<b>Urban Design Observations</b>		<b>Officer:</b>	<b>Stephen Kilmartin</b>
<b>Description:</b>	Land off Waddington Road, Clitheroe		 Ribble Valley Borough Council  www.ribblevalley.gov.uk
<b>Application Ref:</b>	2018/0181	<b>Case Officer:</b> S.K	
<b>Response Ref:</b>	2018/0181/UD/01	<b>Issue Date:</b> 10/07/18

<b>General Observations:</b>
<p><b>1.1</b> The following observations are in relation to Sketch layout DWH-063 SK01 June2018 and following our meeting of the 2<sup>nd</sup> of July 2018.</p> <p><b>1.2</b> Following on from our discussions, you will be aware that there is a requirement to provide ‘Older Persons Housing’ on site comprising 15% of the total number of housing units constructed on site of which 50% will be Affordable Housing Units and 50% Market Housing Units. No details in respect of this provision has been provided in the submission documentation. As you will note from our discussions there will be an expectation that bungalow accommodation will form part of the Older Person Housing provision.</p> <p>Bungalows solely for occupation by those over 55 years of age will have to meet the following definition:</p> <p><b><i>A unit of accommodation/dwelling that shall

Sales Name: AVONDALE - STONE (Plots 16, 32, 44, 53)
 House Type Code: H456---7
 Spec: A2
 Drawn: GDT
 Drawing No: 57, 60, 119, 131
 Date: 05.07.18
 Checked: GDT
 Scale: 1:100

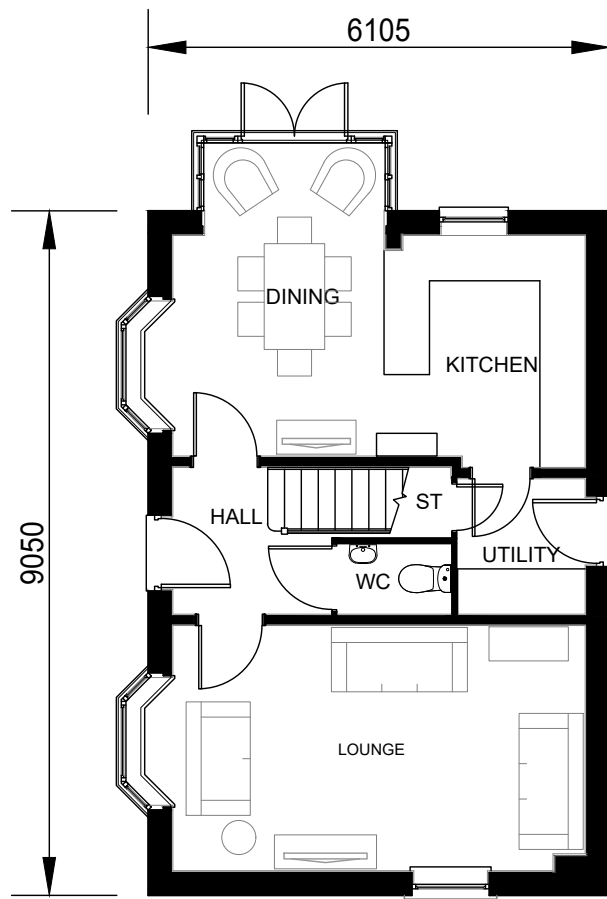
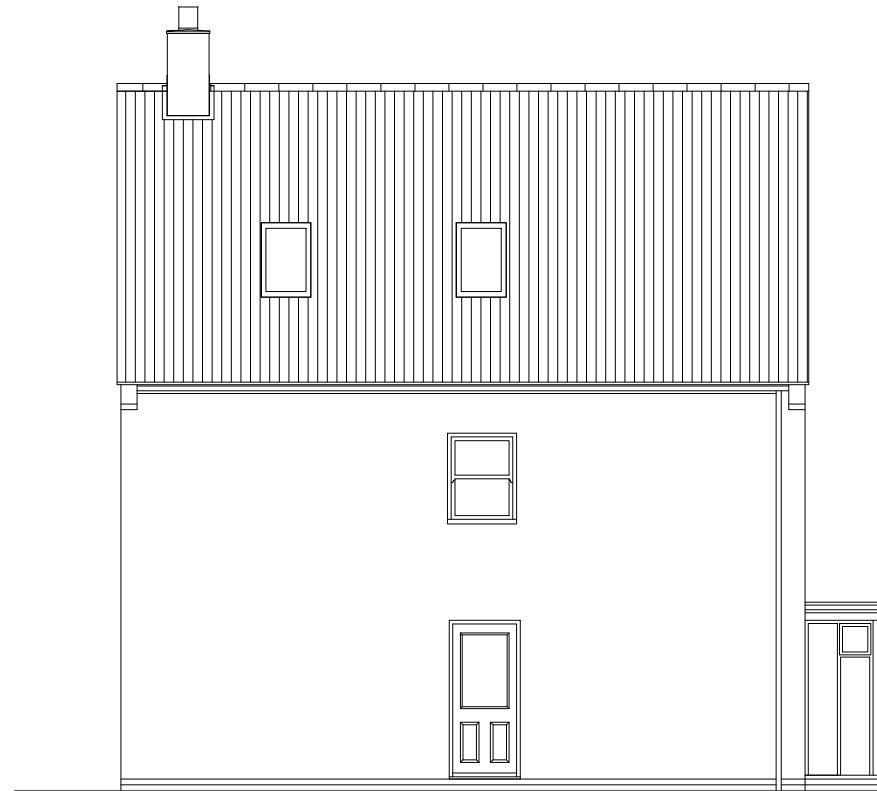
- 2.6** The driveways associated with the '456' plots at the north-western extents of the green corridor should be realigned/relocated to limit their incursion into the green infrastructure associated with the most northern section of the 'green corridor'. This was discussed at our recent meeting, with agreement having been reached that the extent of driveway coming off the main spine road could be omitted and the driveways to the east (types 456, 411 and 403) should also be realigned to avoid conflict with the enhanced pedestrian route.

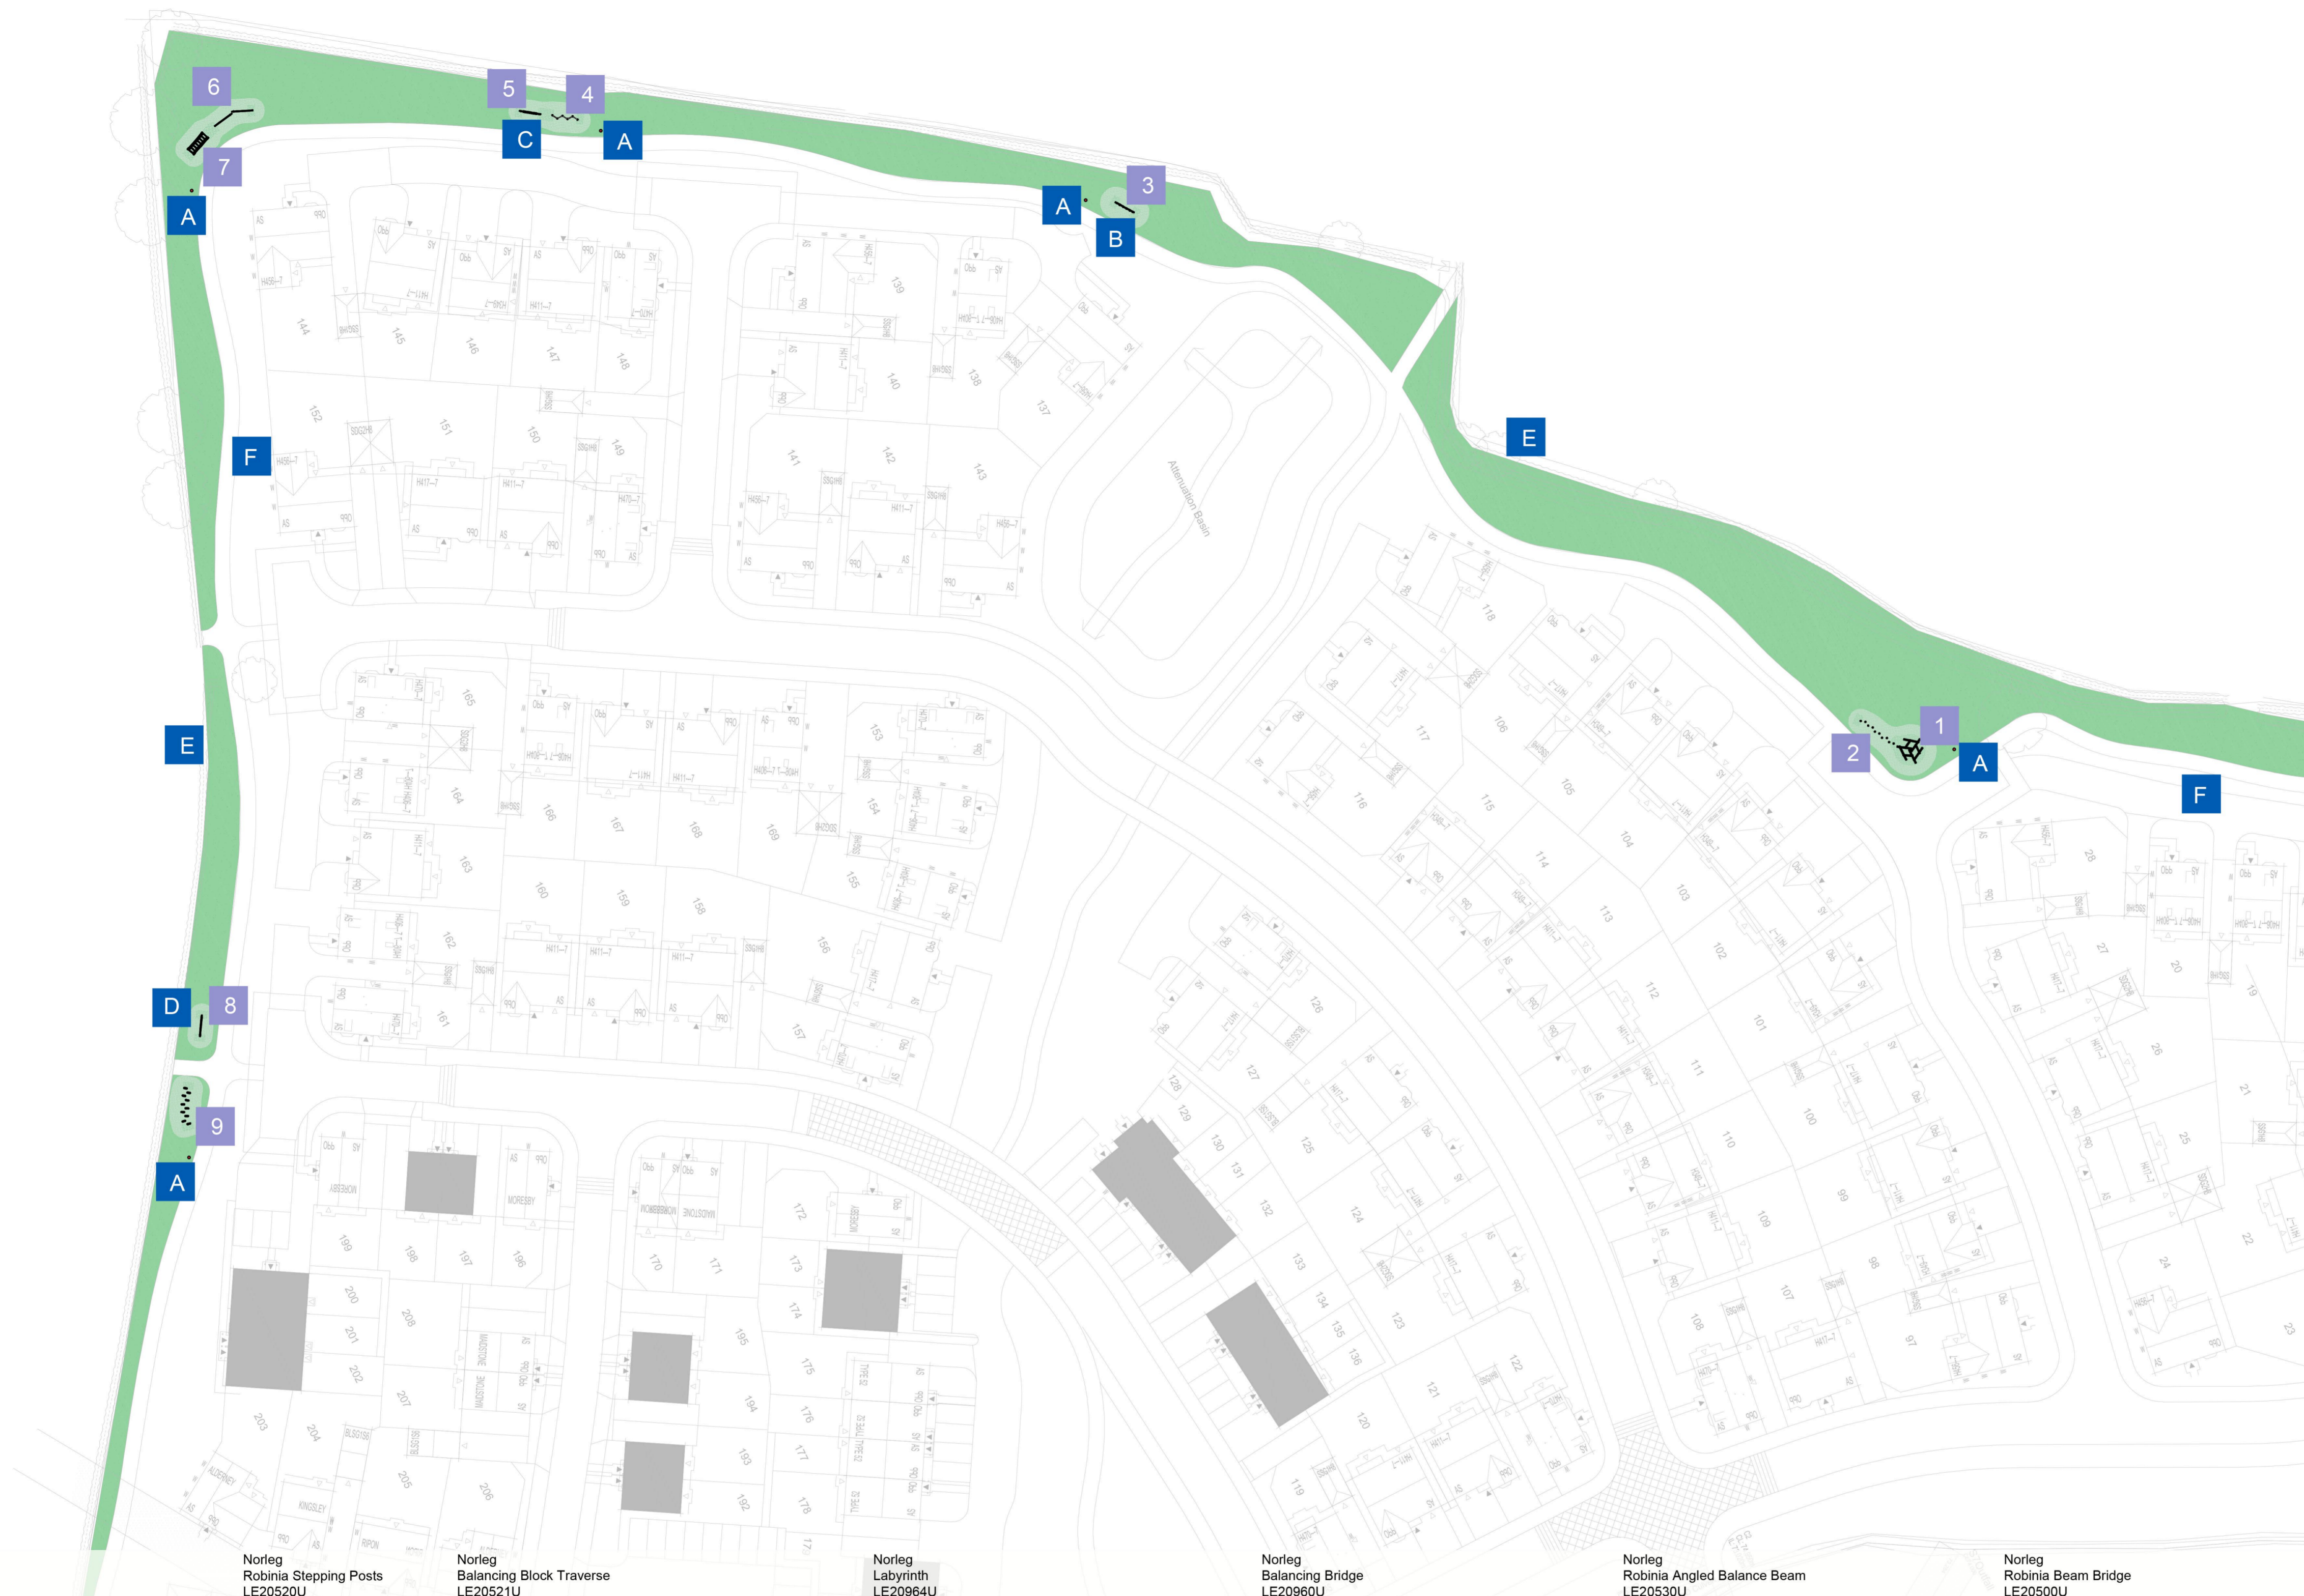
- 2.4** The above referenced green corridor should also include the provision of areas of usable open space,

I would be preferable if such areas were largely 'informal' in nature and encouraged 'naturalistic play' however there will be the expectation that this area will accommodate play equipment of a form and type to be agreed.
